Our ref: 21/16

Your ref: MP06_0228_Mod 21

**RE: SHOALHAVEN STARCHES EXPANSION PROJECT - MODIFICATION 21
FURTHER COMMENTS FROM EPA AND SHOALHAVEN COUNCIL**

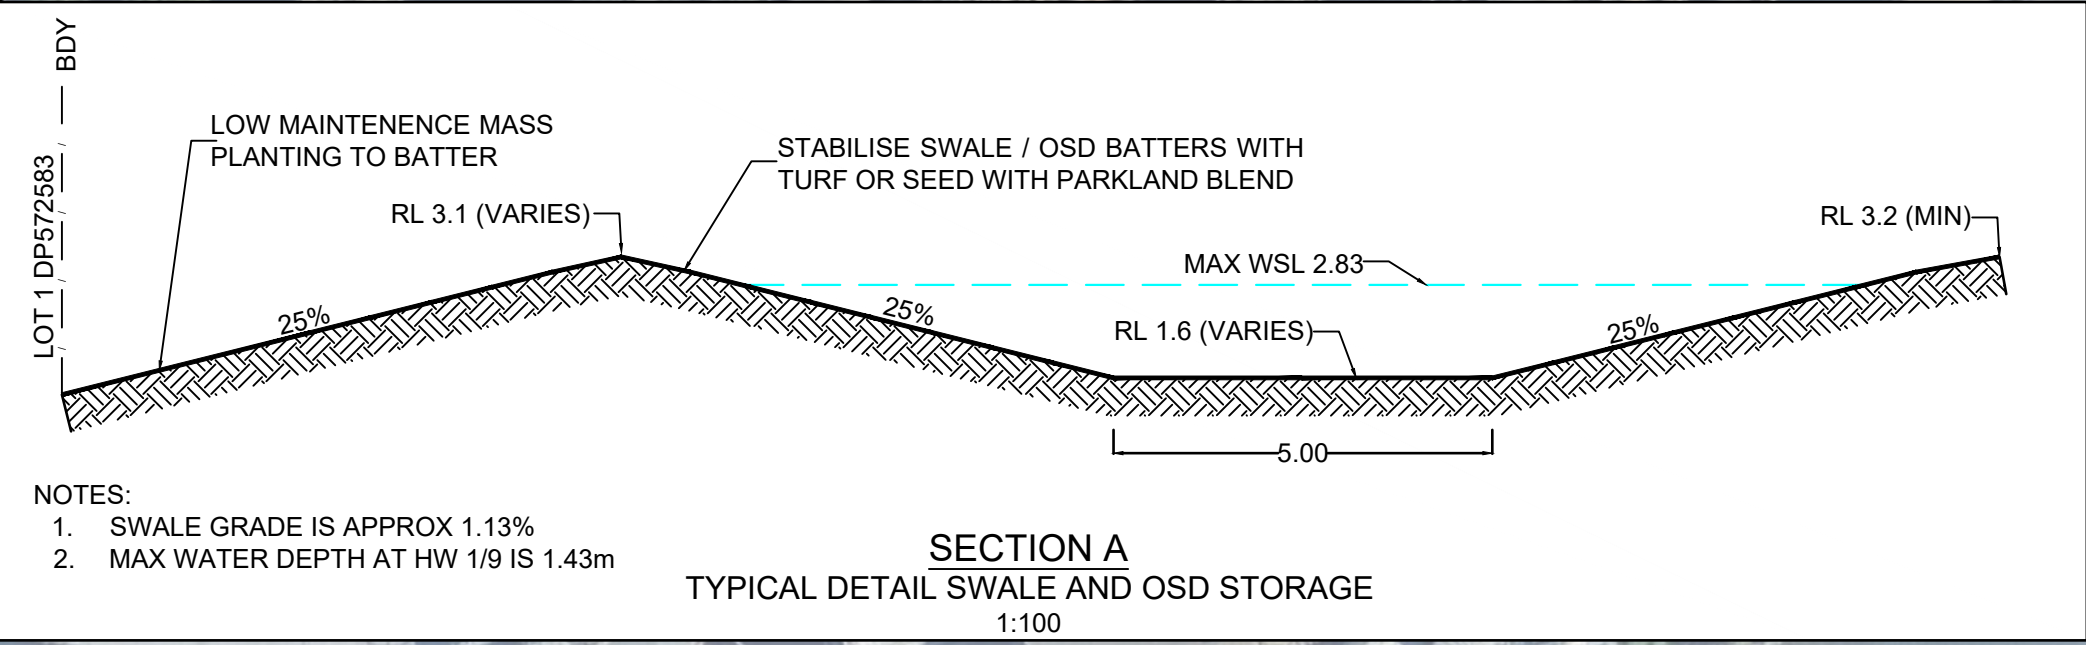
Further information is requested for the design of the OSD (e.g., typical section, depth of ponding). The IWCMS notes that the device is not located in landscaped areas and is in an 'out of bounds' area. Details will need to be provided to confirm how that area is to be managed and the Site Safety Protocols.

- A submission prepared by Allen Price & Scarratts (APS) responding to Council's comments in relation to the IWCMS.
- The APS submission also addresses issues raised in relation to the OSD in terms of what is meant by an "Out of Bounds" area and how this area will be maintained.
- A modified IWCMS Stormwater Concept Plan including details relating to a typical section and depth of ponding.
